**Tillbridge Solar Project – EN010142**

**Section 51 advice regarding draft application documents submitted by Tillbridge Solar Limited**

On 23/01/2024 Tillbridge Solar Limited submitted the following draft documents for review by the Planning Inspectorate as part of its Pre-application Service<sup>1</sup>:

Key Plan

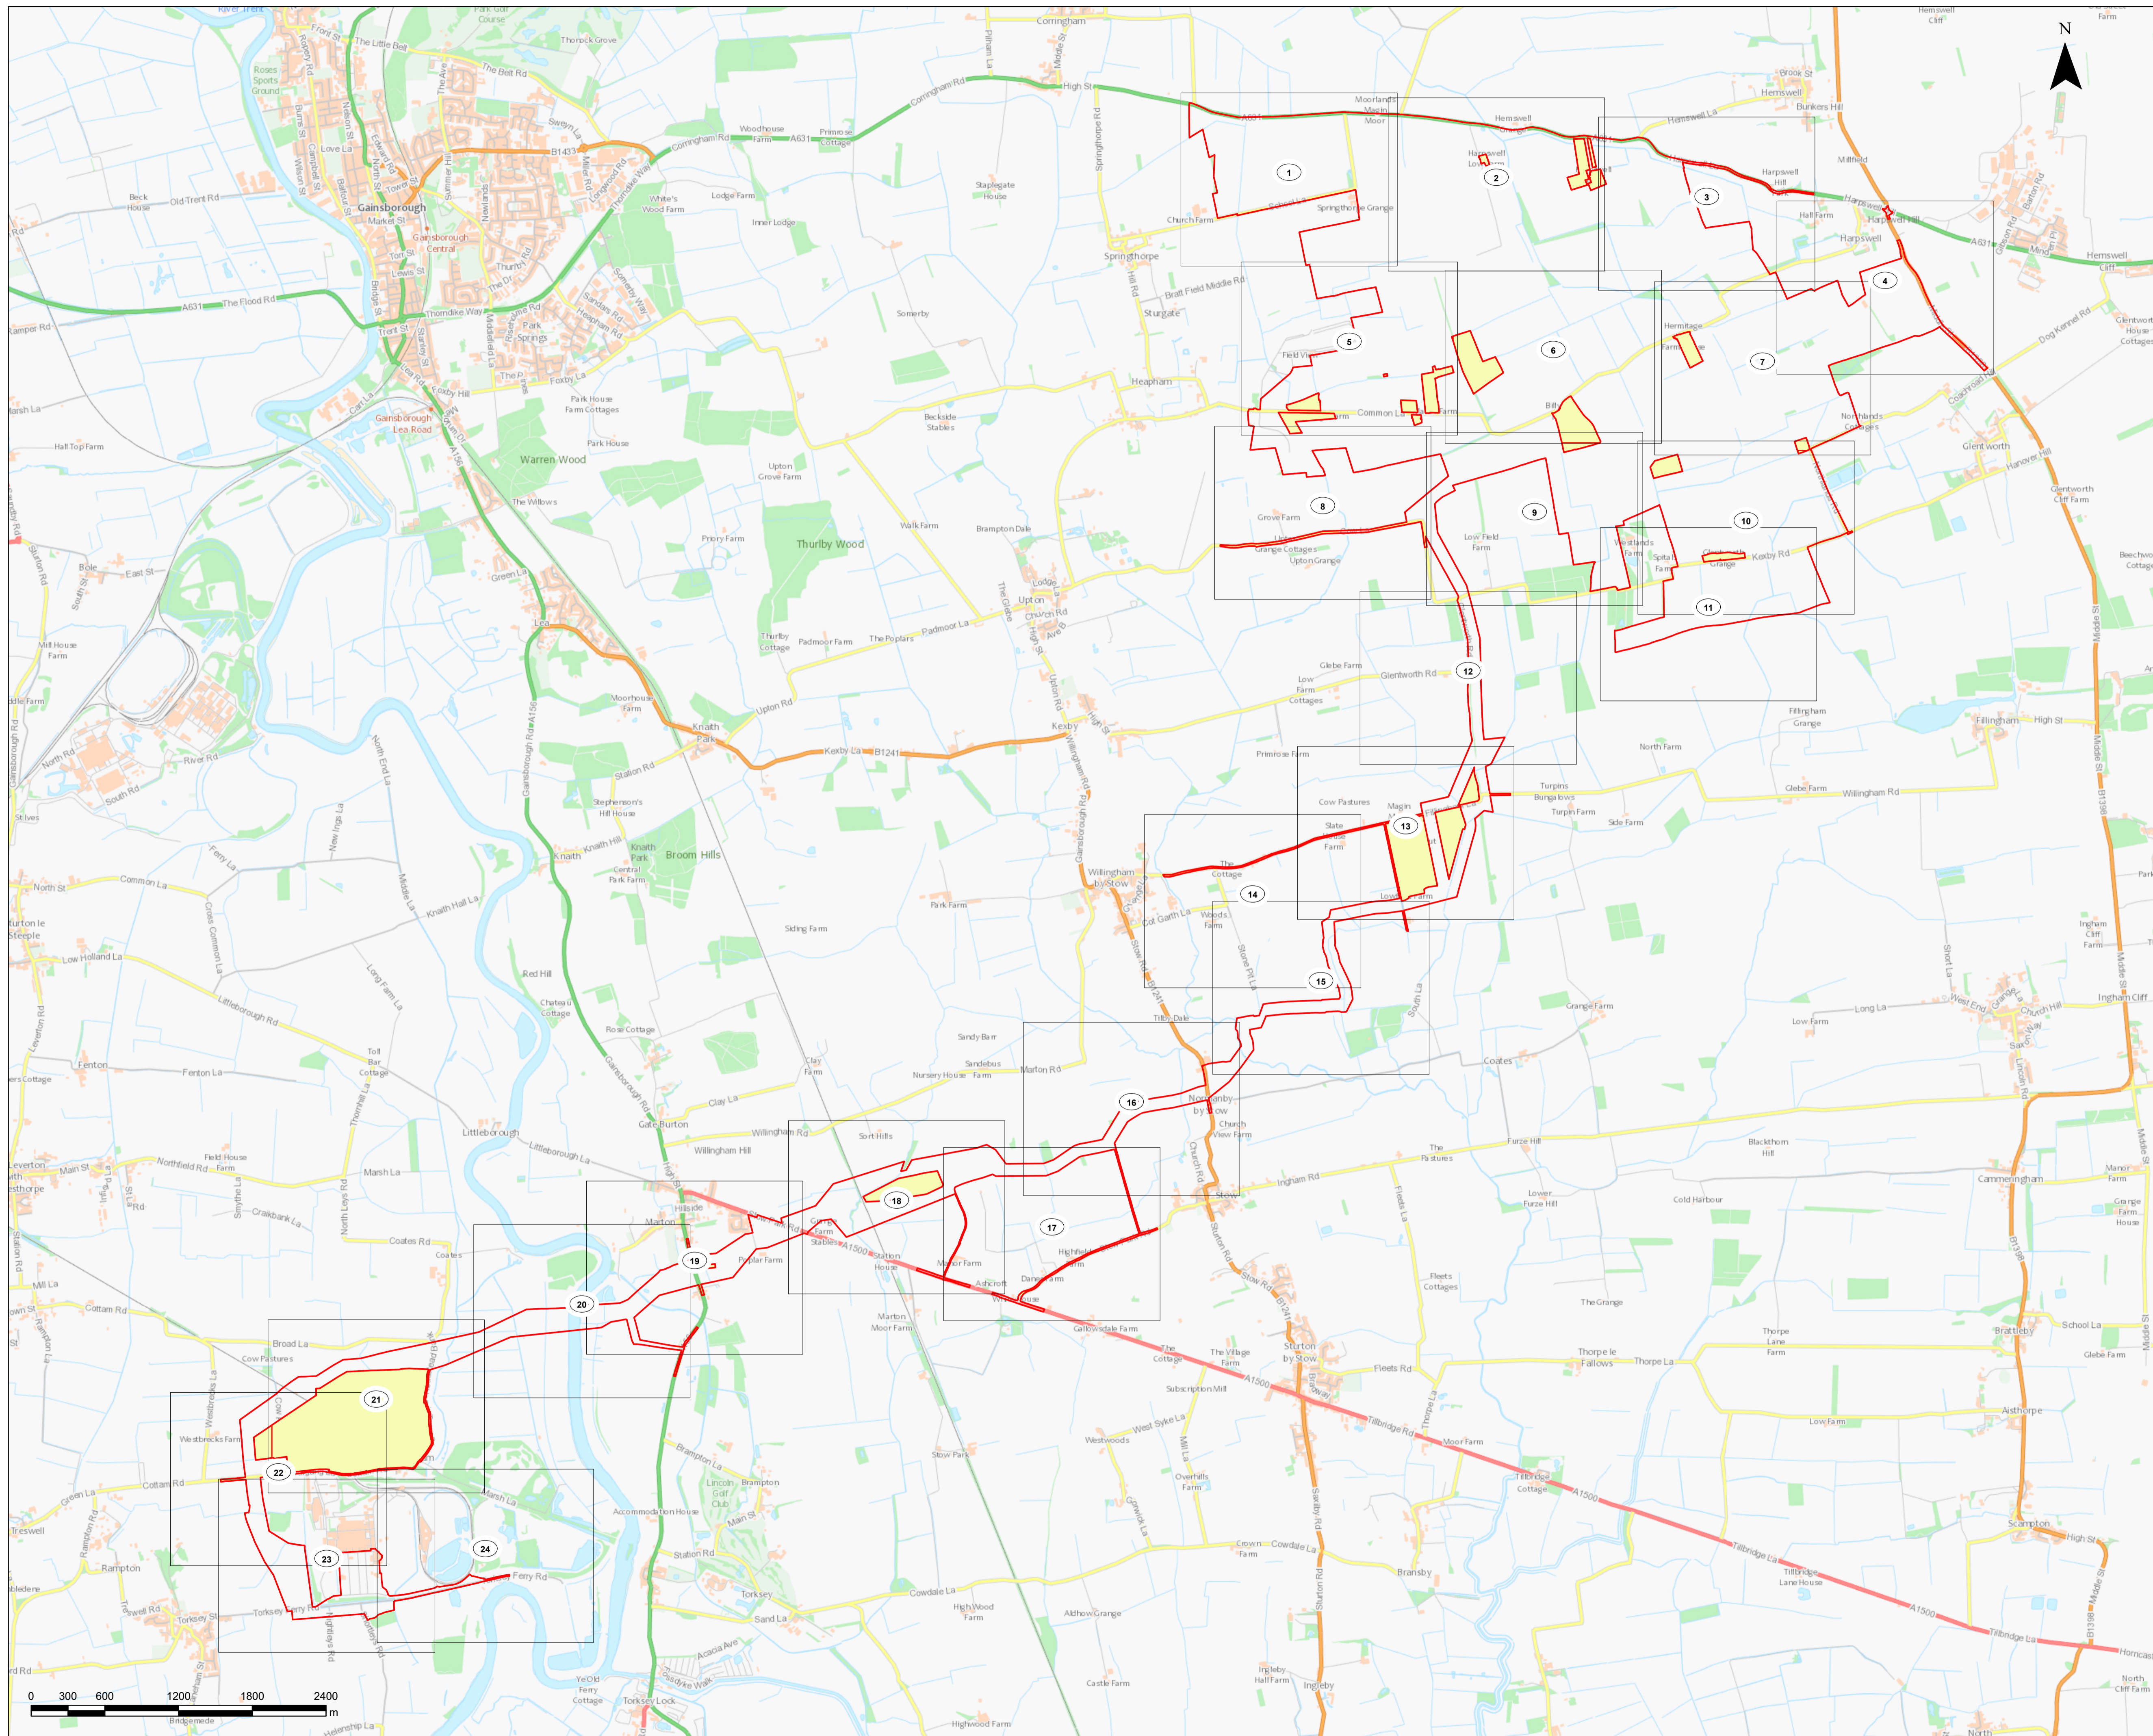
Tillbridge Solar - Crown Plan		
Ref No.	Plan ref	Comment/Question
1.	Key Plan	<p><a href="#">It is noted that there is only one plot and/or land parcel earmarked as Crown Land being plot 20/11. The Applicant may wish to review other submitted DCO Solar Farm applications, with similar features, such as Gate Burton Crown Land Plan.</a></p> <p><a href="#">Permanent acquisition of rights 20/11</a></p> <p>Heavy overlap of area in Sheets 19-24. To avoid unnecessary documents, Applicant should endeavour to reduce the number of sheets.</p>
